# CITY OF ALBUQUERQUE

April 22, 2019

**Re: Durango Subd Units 3-5  
Erosion Sediment Control Plan  
Engineer's Stamp Date 4-16-19 (C09E012A)**

ESC-1

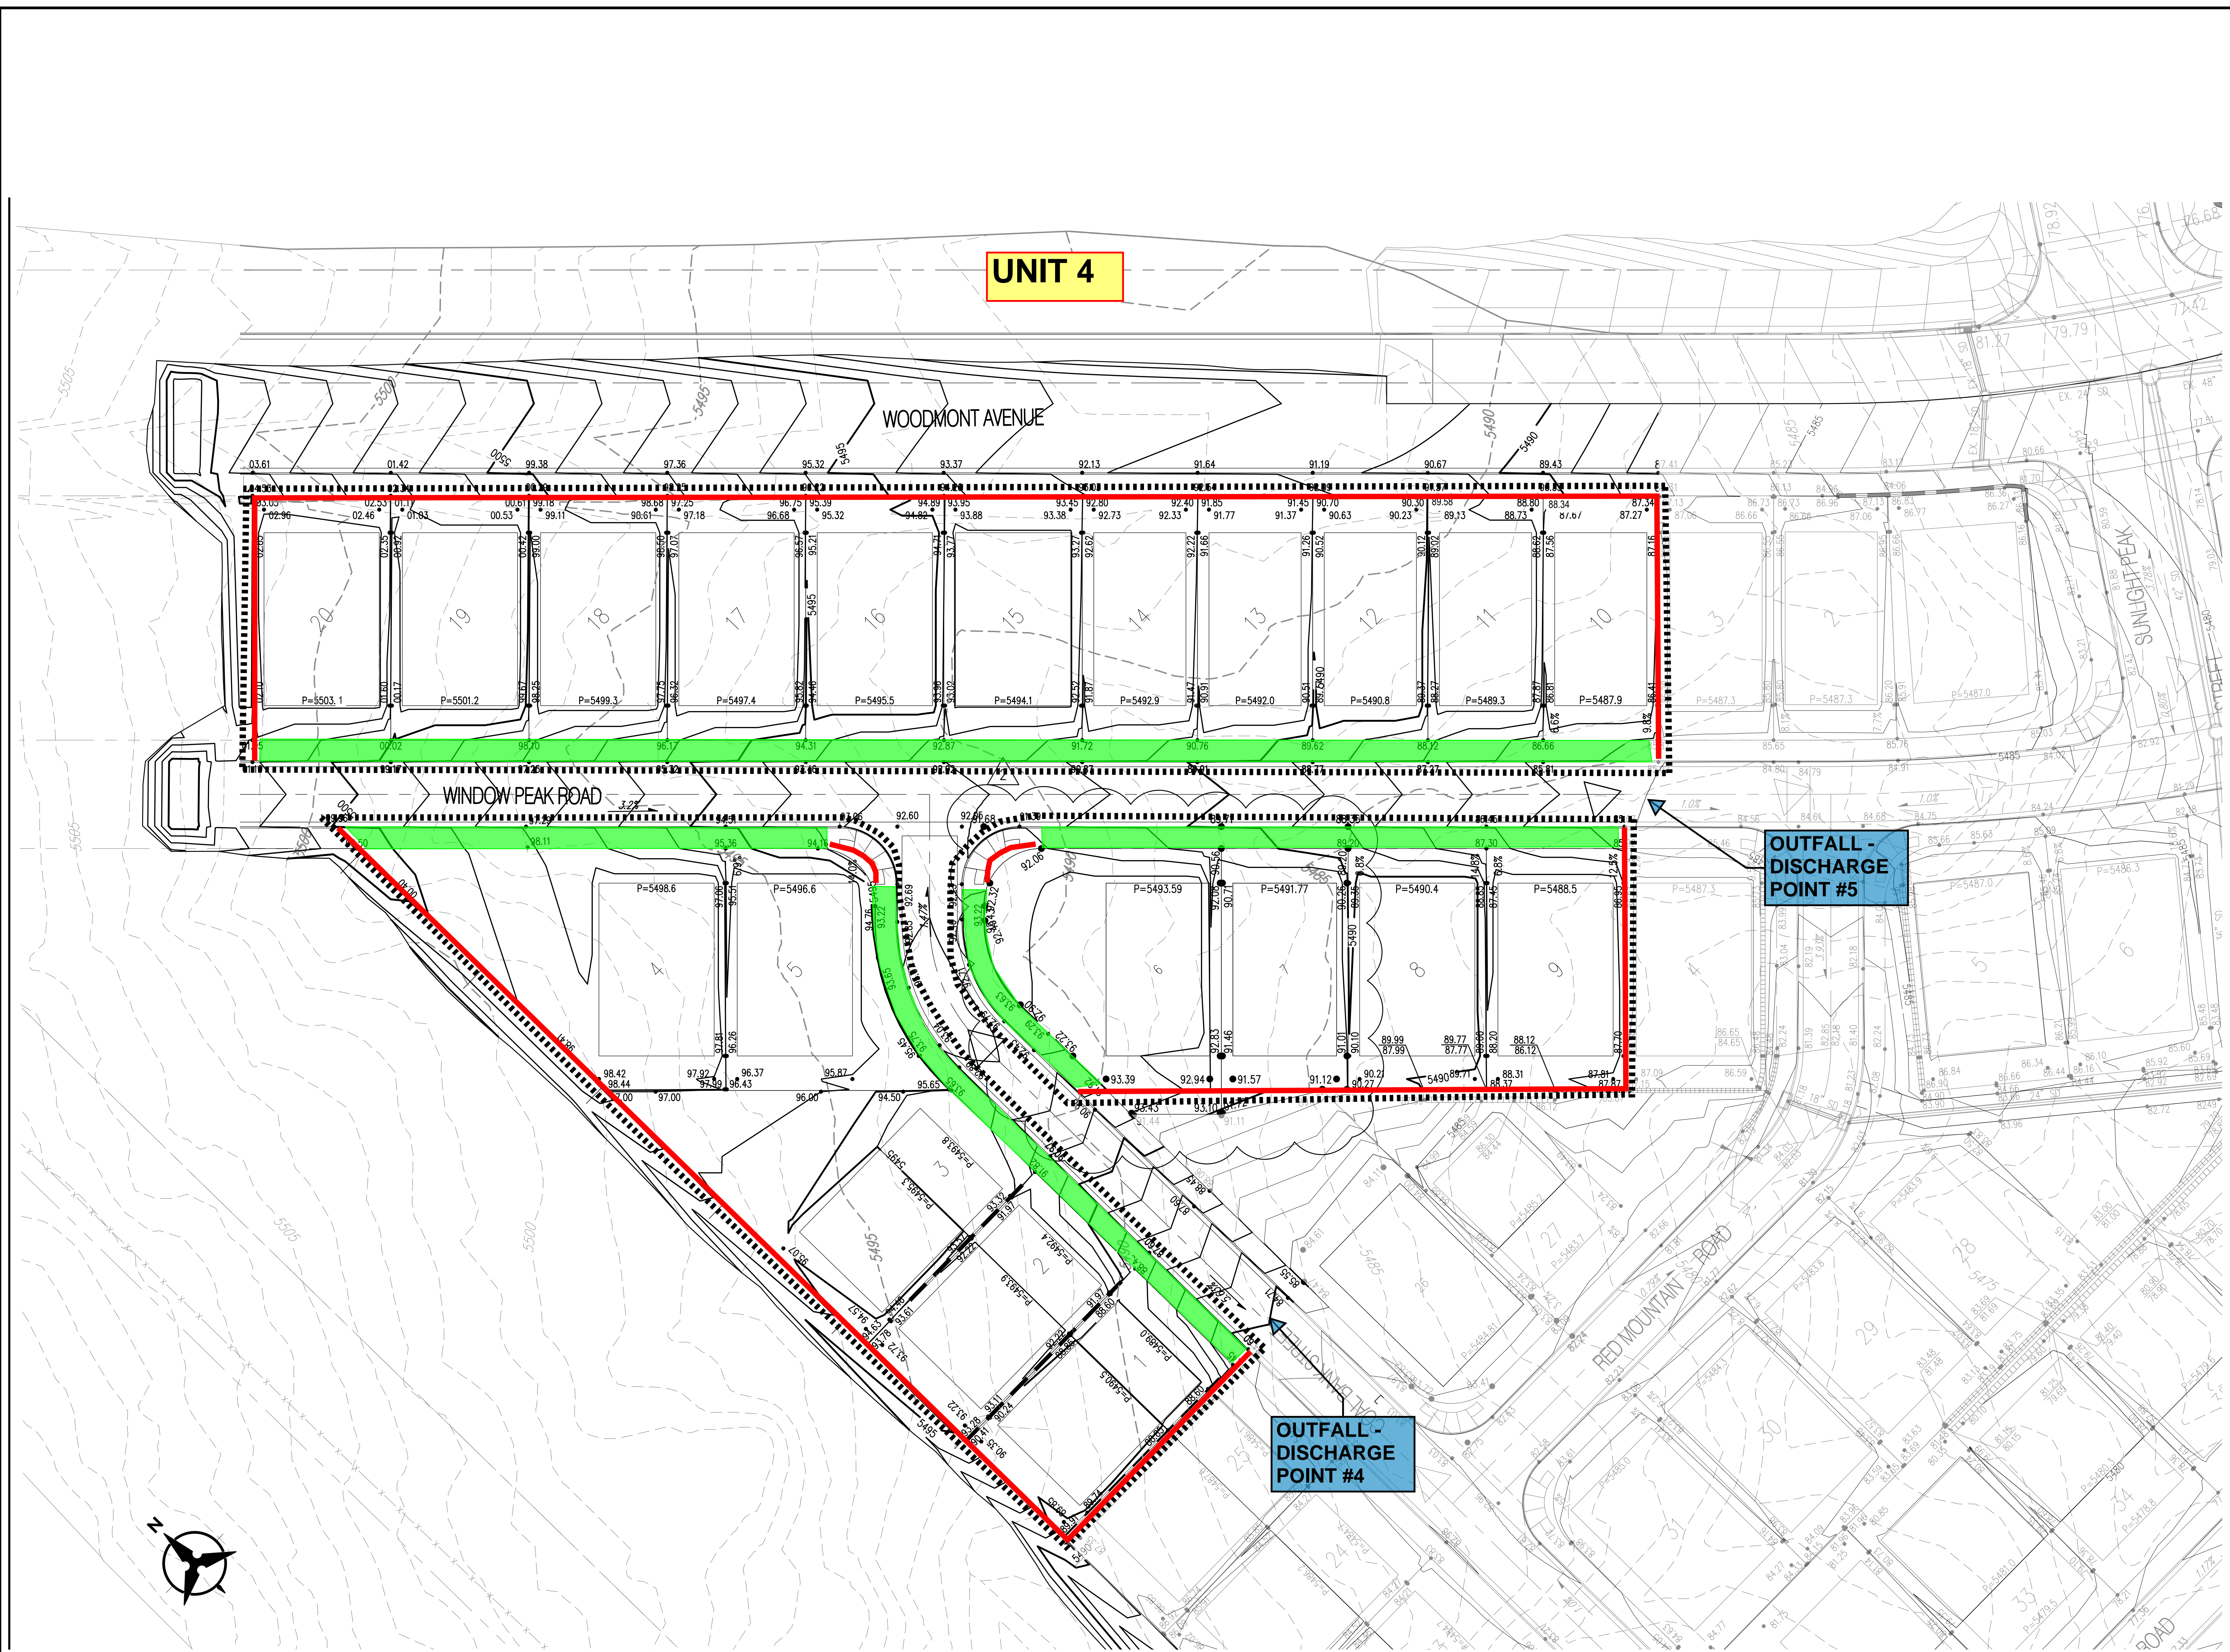
1. The storm drain inlets in Molas Road located at and downhill from the VTC will most likely require protection.
